Holiday Coast Bushfire Solutions

17th June 2010

SANDY BEACH MILL PROPOSED SUBDIVISION LOT 260 DP 1110719 GRAHAM DRIVE, SANDY BEACH

I refer to my Bushfire Hazard Assessment Report issued 11/6/2009, and provide this letter of advice as an addendum to that Report. The advice herein is in response to:

Figure 14: copy of survey plan showing construction Level thresholds

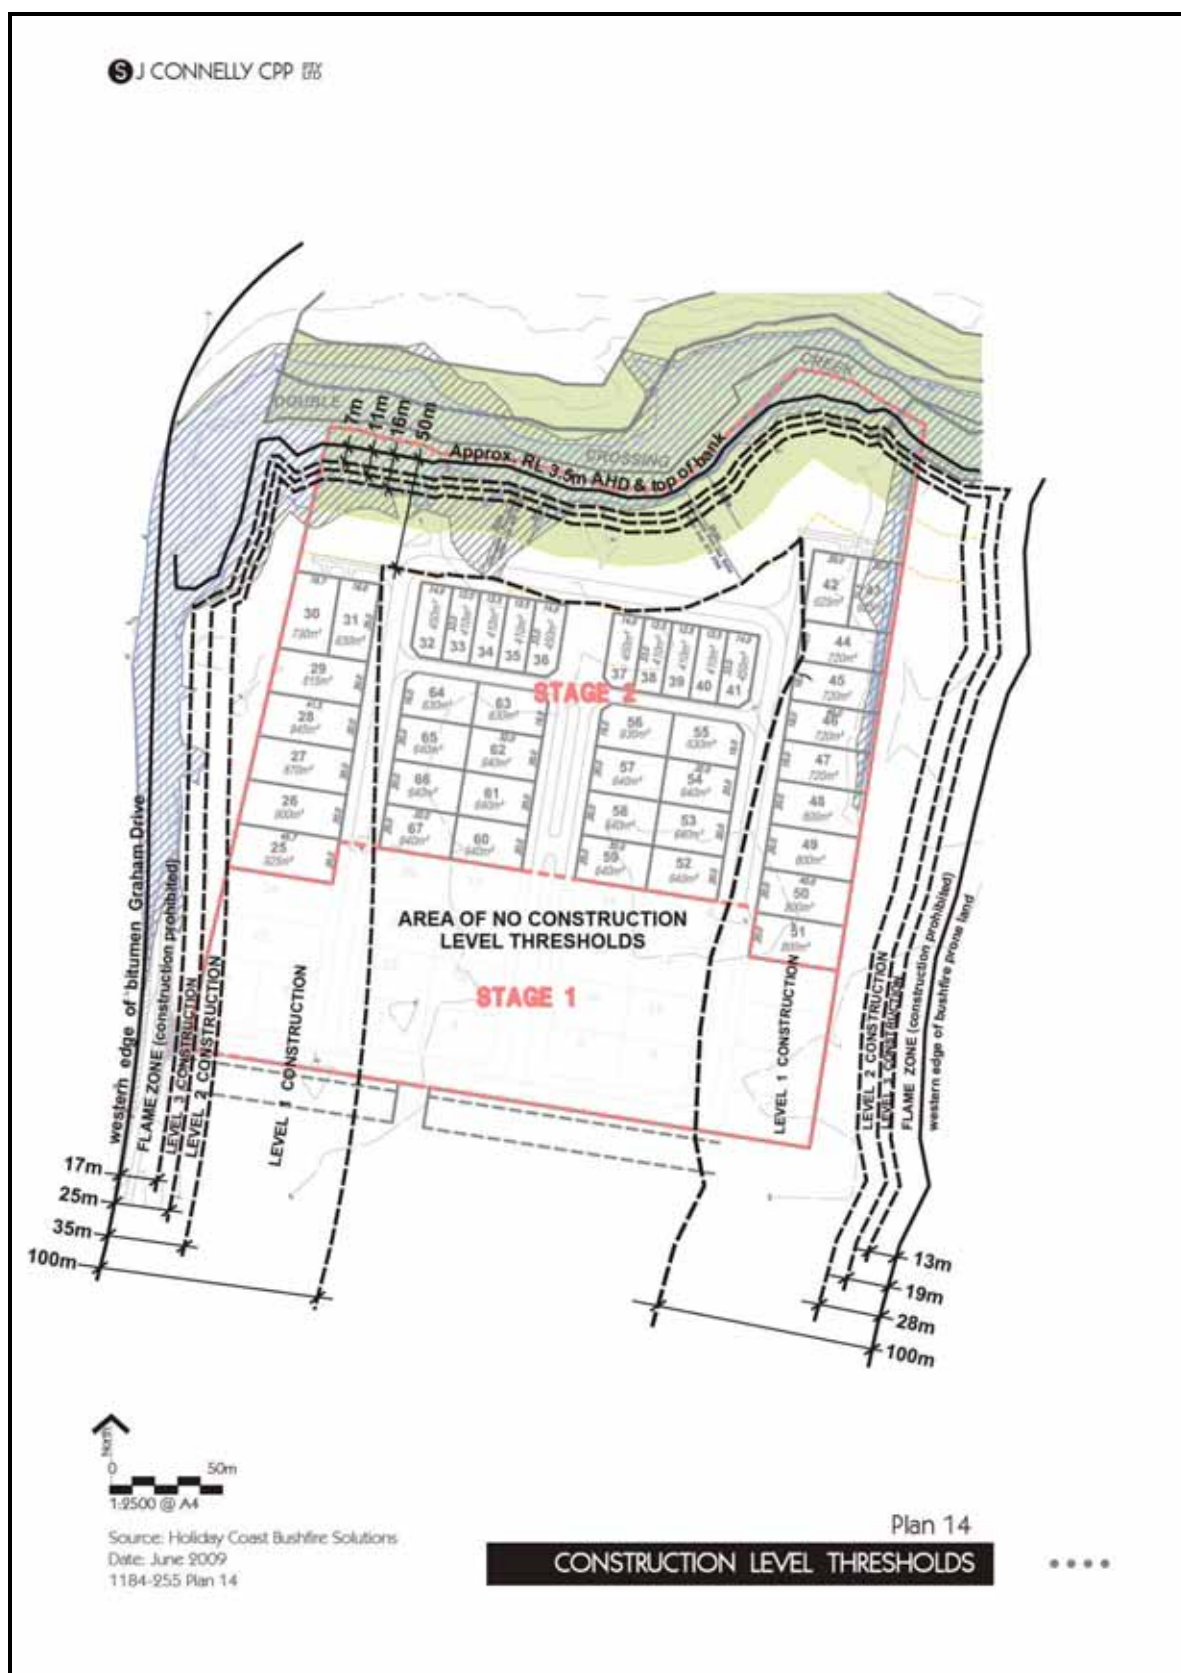
If the wedge-shaped portion of land is to be managed by CHCC in line with existing road-side vegetation management practices, rather than as an APZ, then the construction level thresholds as indicated on the Figure 14 of my Report will need to be amended.

The required separation was 17m, made up of 10m outer protection area (OPA) and 7m inner protection area (IPA), as provided by Appendix 2 of **PBP-2006**. Where the road-side vegetation is managed by the CHCC consistent with its existing management of road-side vegetation it will constitute the OPA. Therefore the Flame Zone will extinguish at 7m from the western boundary of the site.

Figure 13: Construction Level Thresholds (source: Holiday Coast Bushfire Solutions)

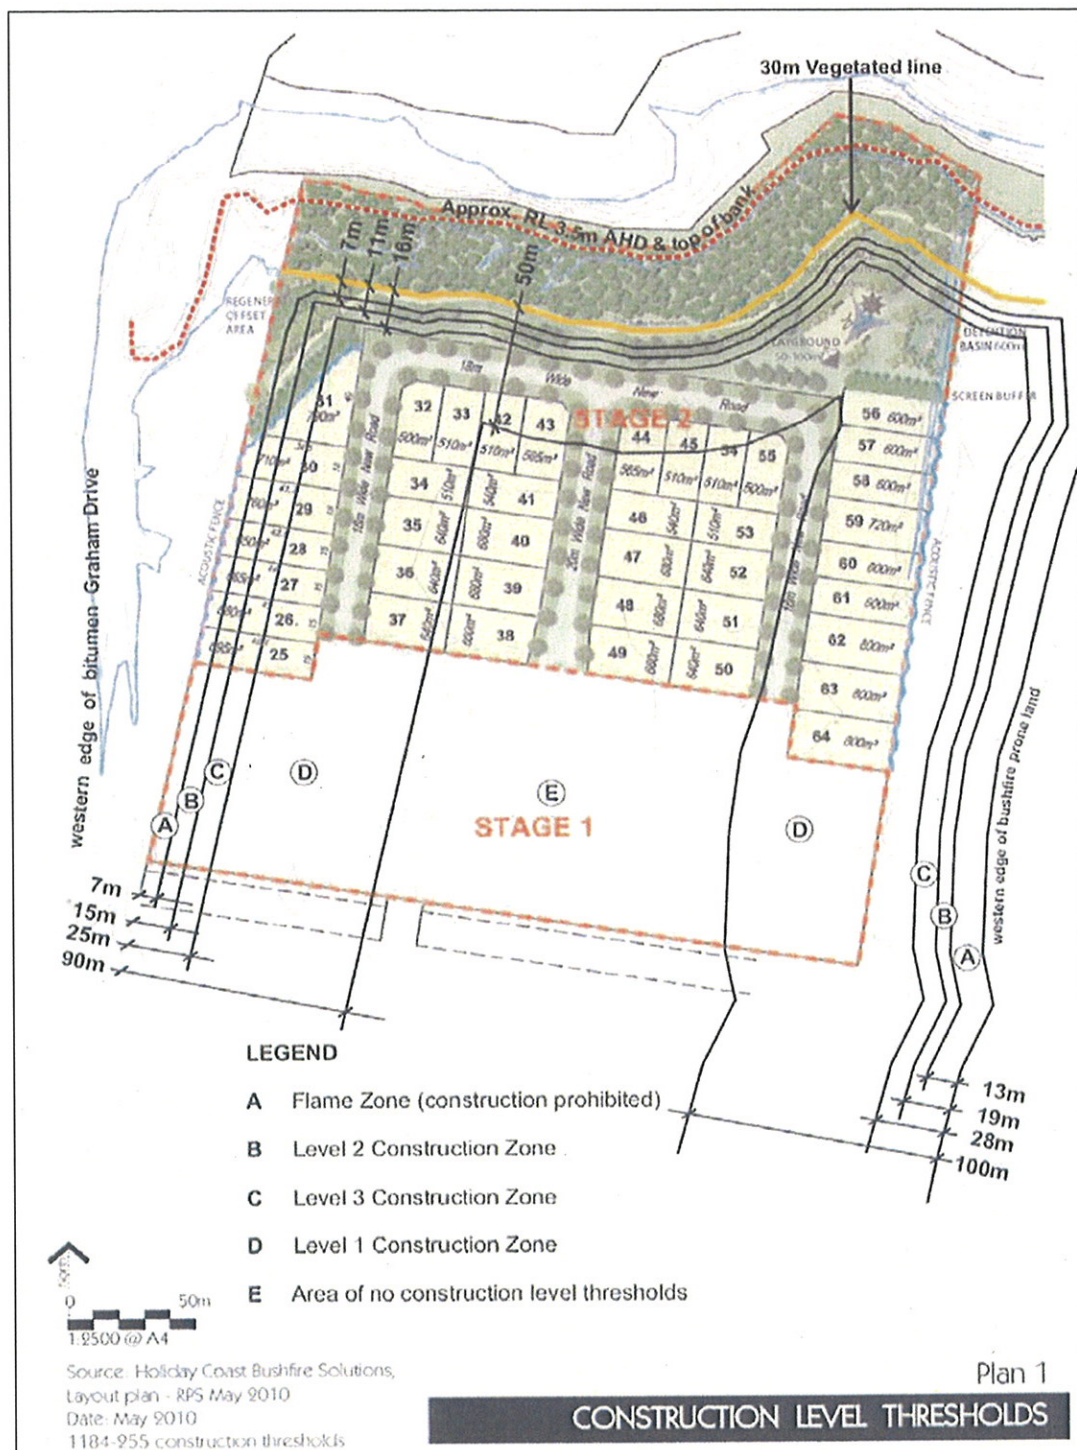
The plan on page 27 of my Report reflected the concession provided in *PBP-2006*. However, you have advised that this riparian area is to be revegetated as provided below in your e-mail dated 7/6/2010:

CHCC have agreed that revegetation of the 50m riparian buffer to Double Crossing Creek should generally be carried out such that the first 20m from top of bank is to be heavily vegetated, representative of vegetation located east and west of the site, the next 10m is to be less heavily vegetated, while the final 20m is to comprise isolated trees and shrubs with a turfed understorey.

The description of the revegetation above indicates that APZ-conditions (outer protection area) will exist at a distance of 20m from the top of the creek bank, therefore, the concession provided by **PBP-2006** will still apply. The attached plan reflects the impact the revegetation has on the construction level threshold across the site, and replaces the plan provided at page 27 of my original Report.

SR4 The construction requirements of future dwellings should be determined in accordance with the plan attached as Figure 1 to this Addendum, and the NSW Rural Fire Service “Fast Fact 02/2010 – BCA 2010 Transition”.
